Yarnton, Cherwell

Application Comments Response Note

162751A/N03

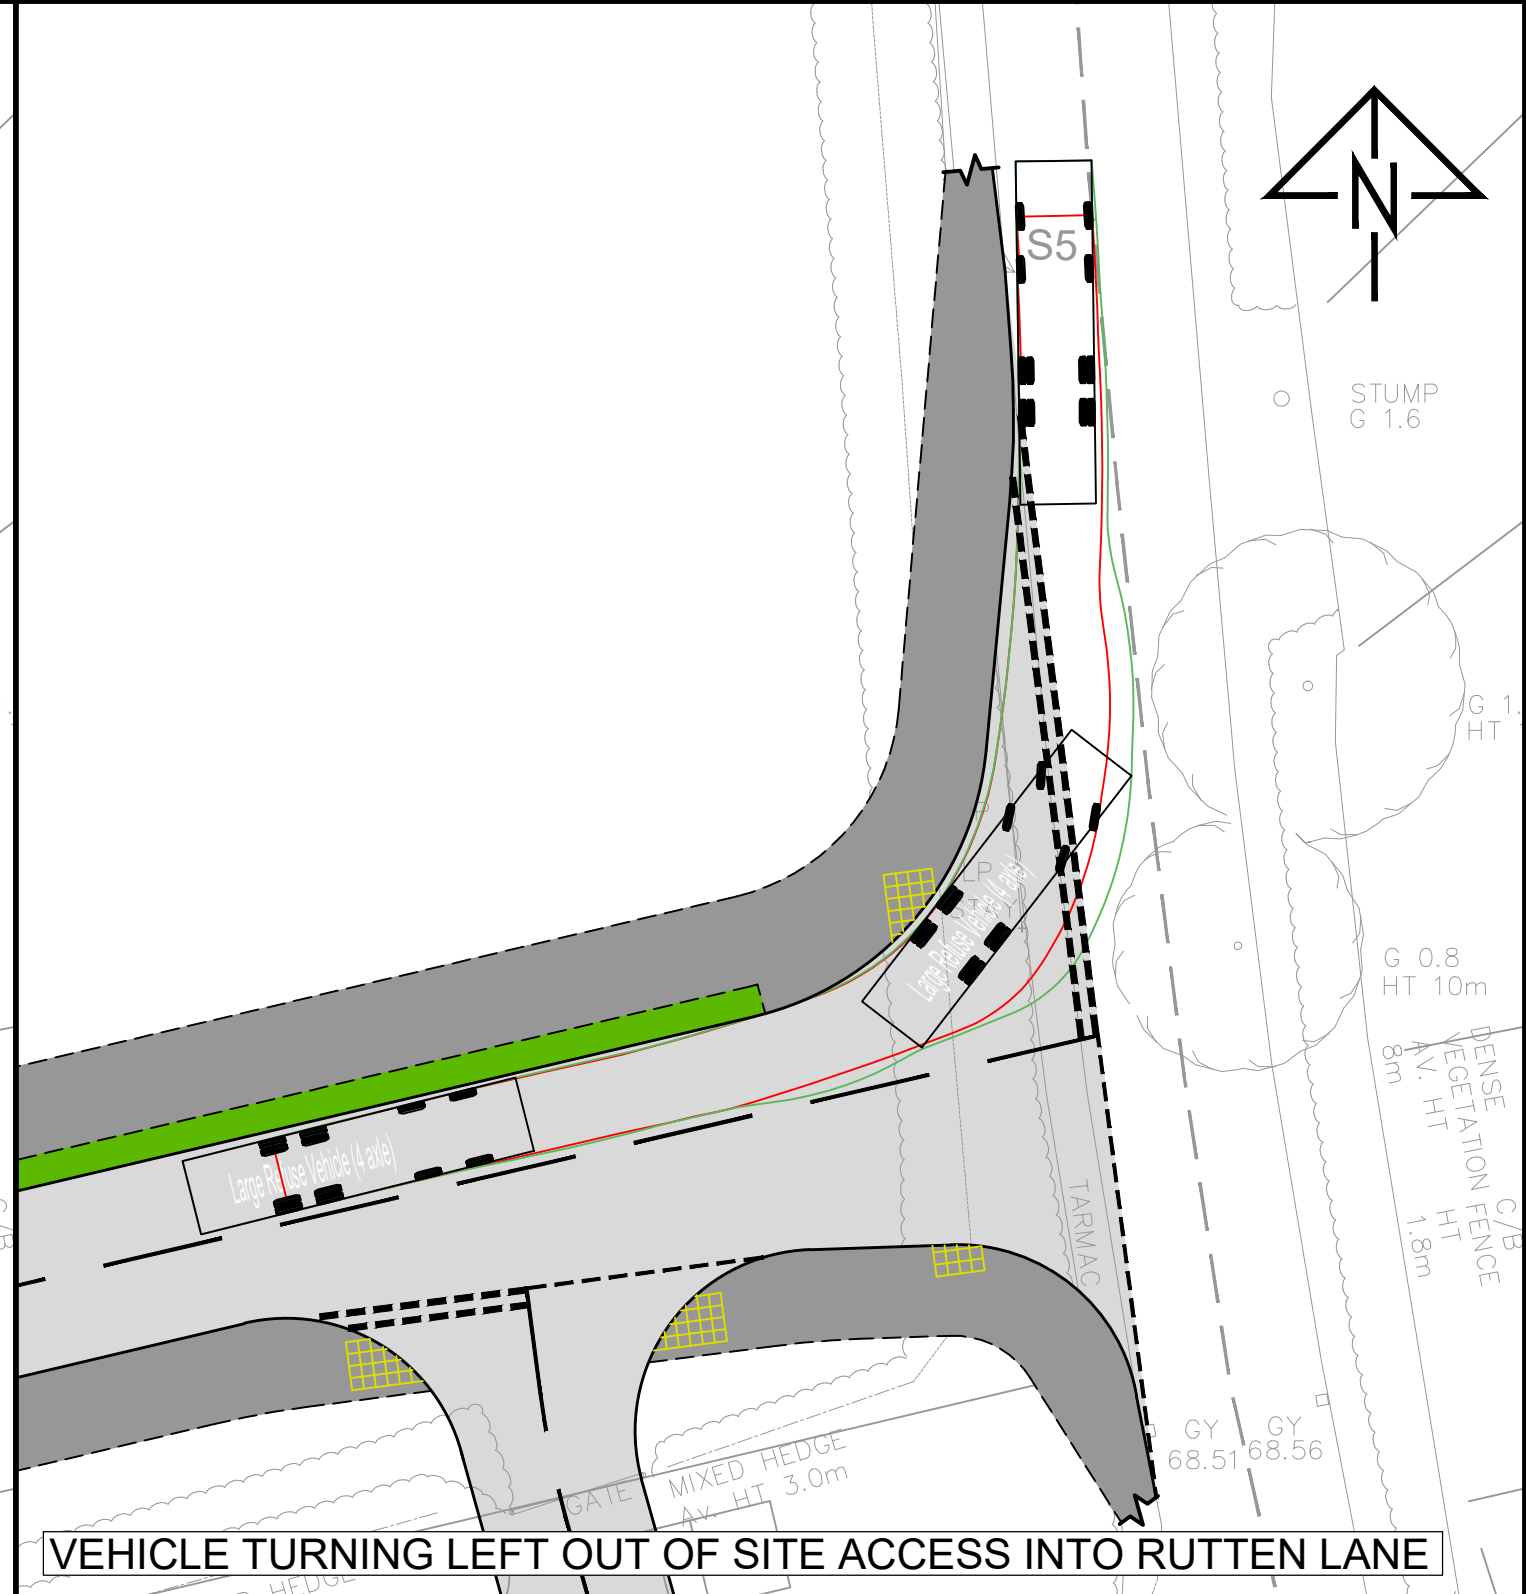
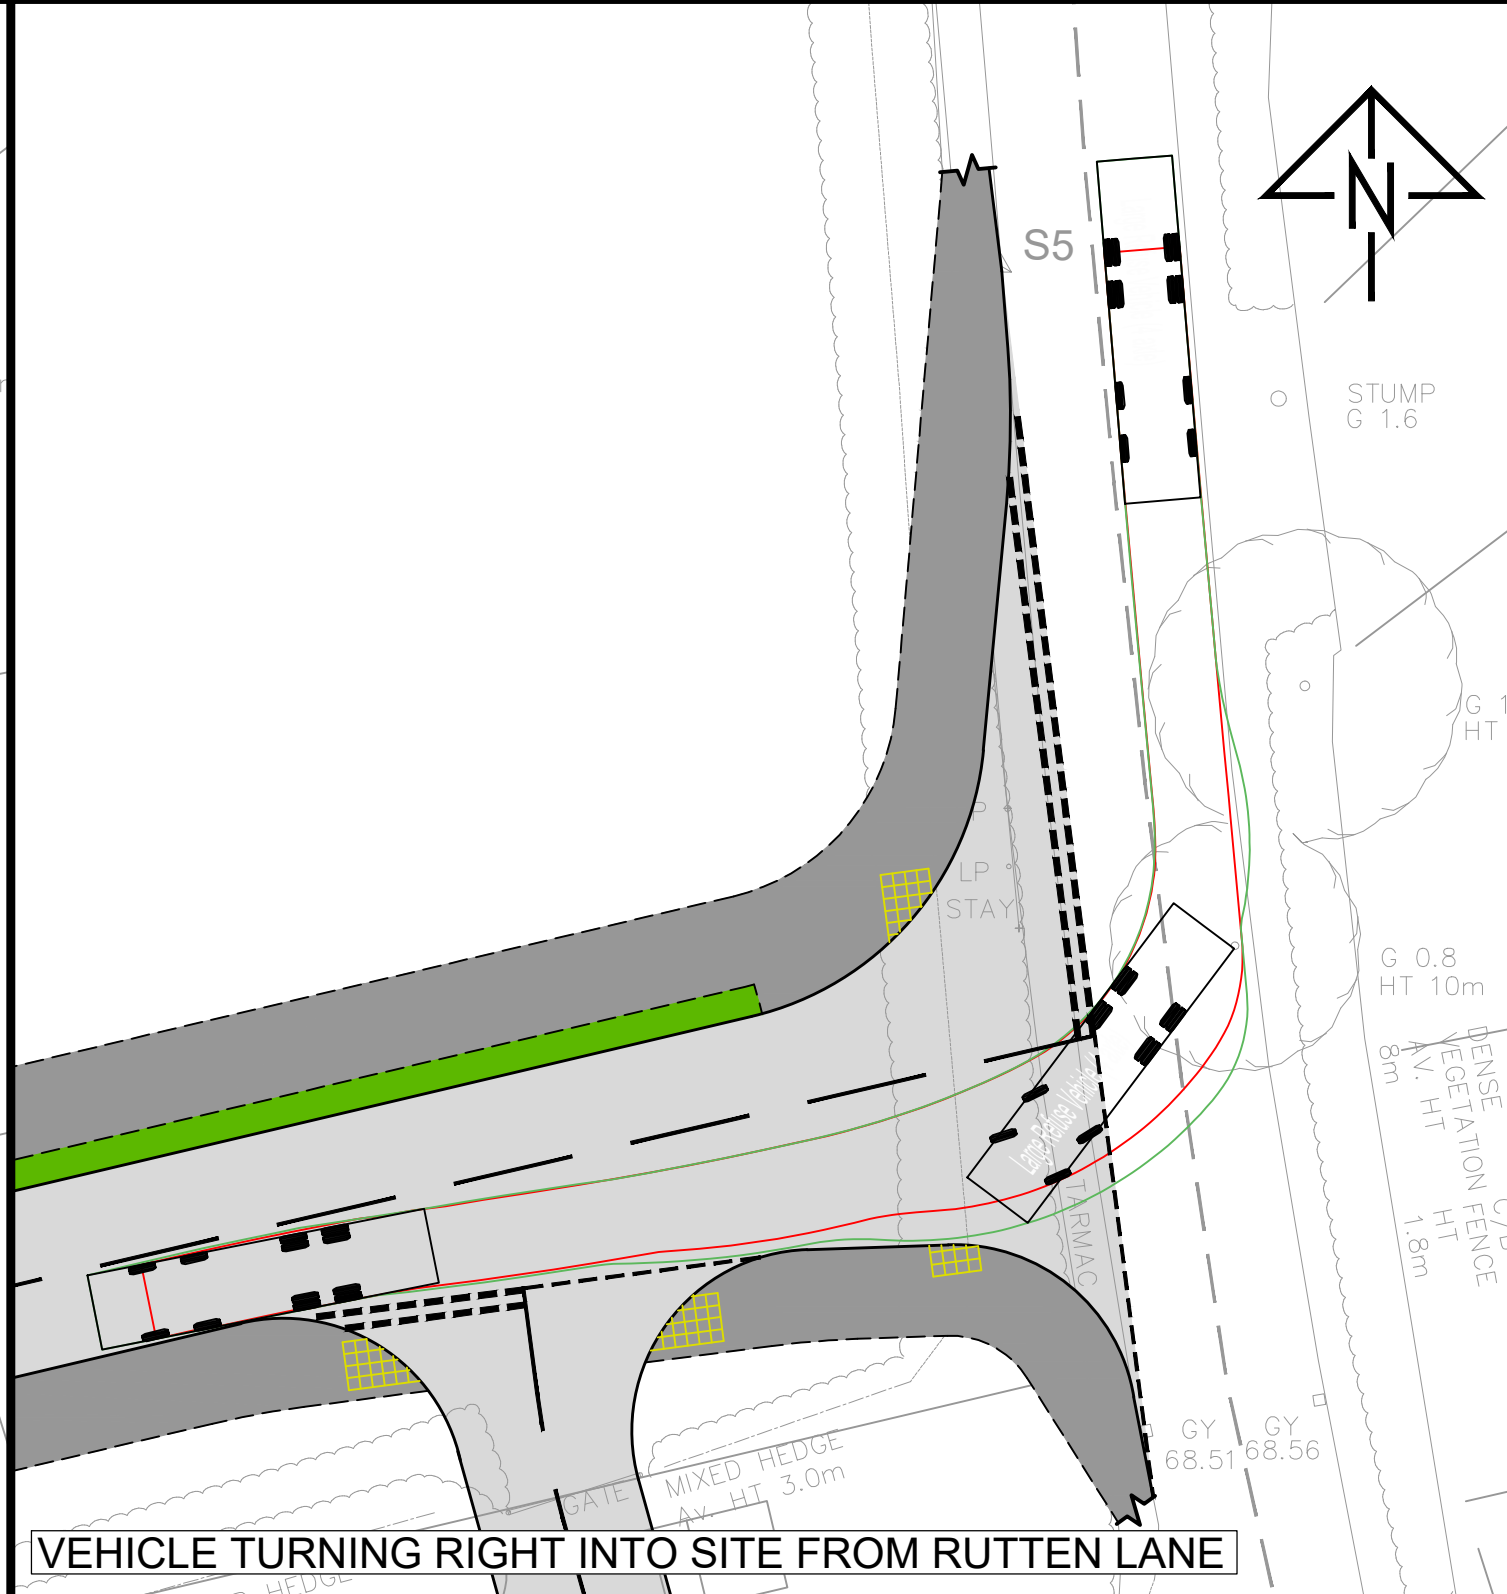
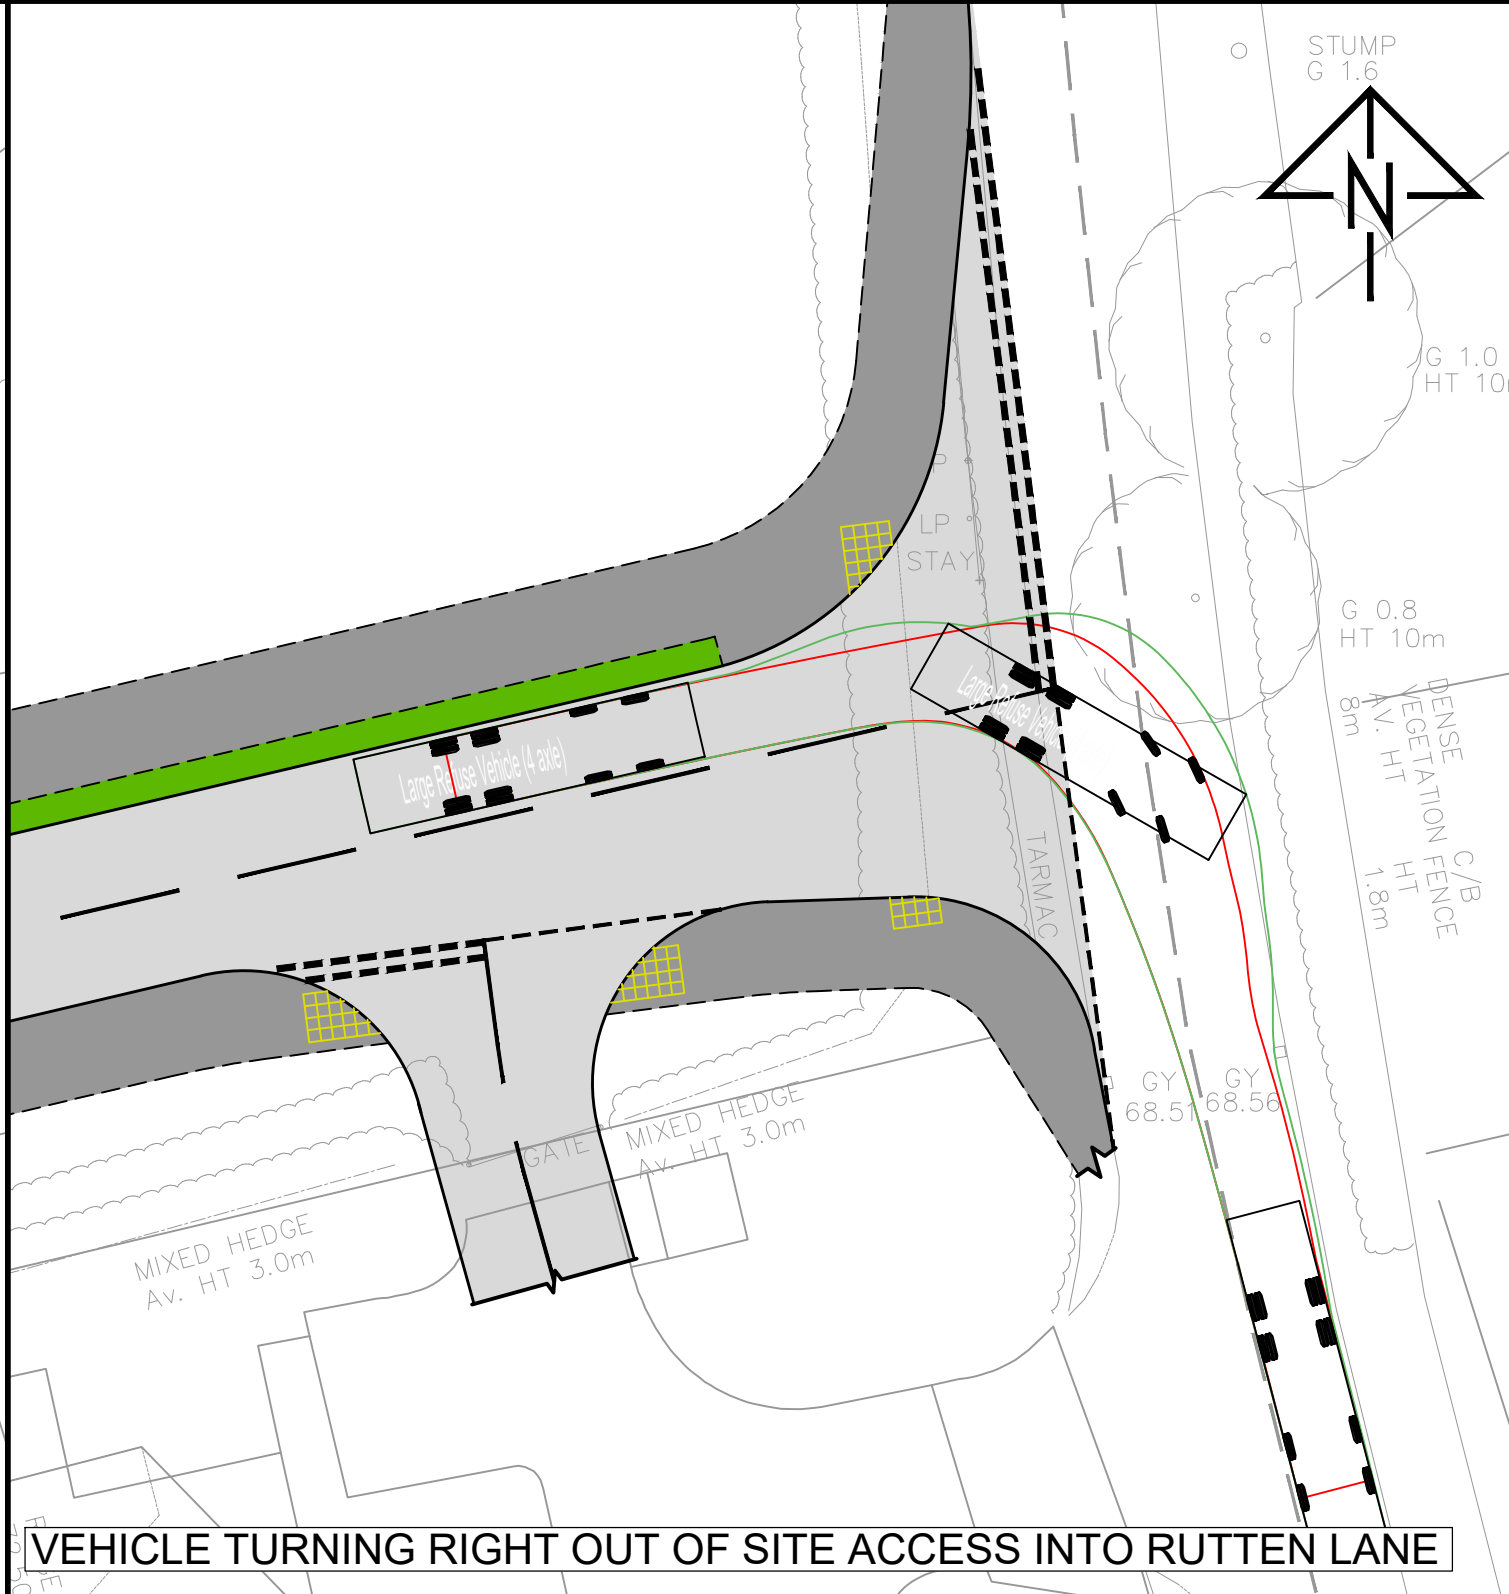
- Drawing 162751/B01/AT01 Rev D – tracking of the A44/ Begbroke Science Park access;
 - Drawing 162751A/PD02 Rev A – visibility splays in the vertical plane which show that the gradient of Rutten Lane is not a constraint to achieving suitable visibility, as contended by YPC;
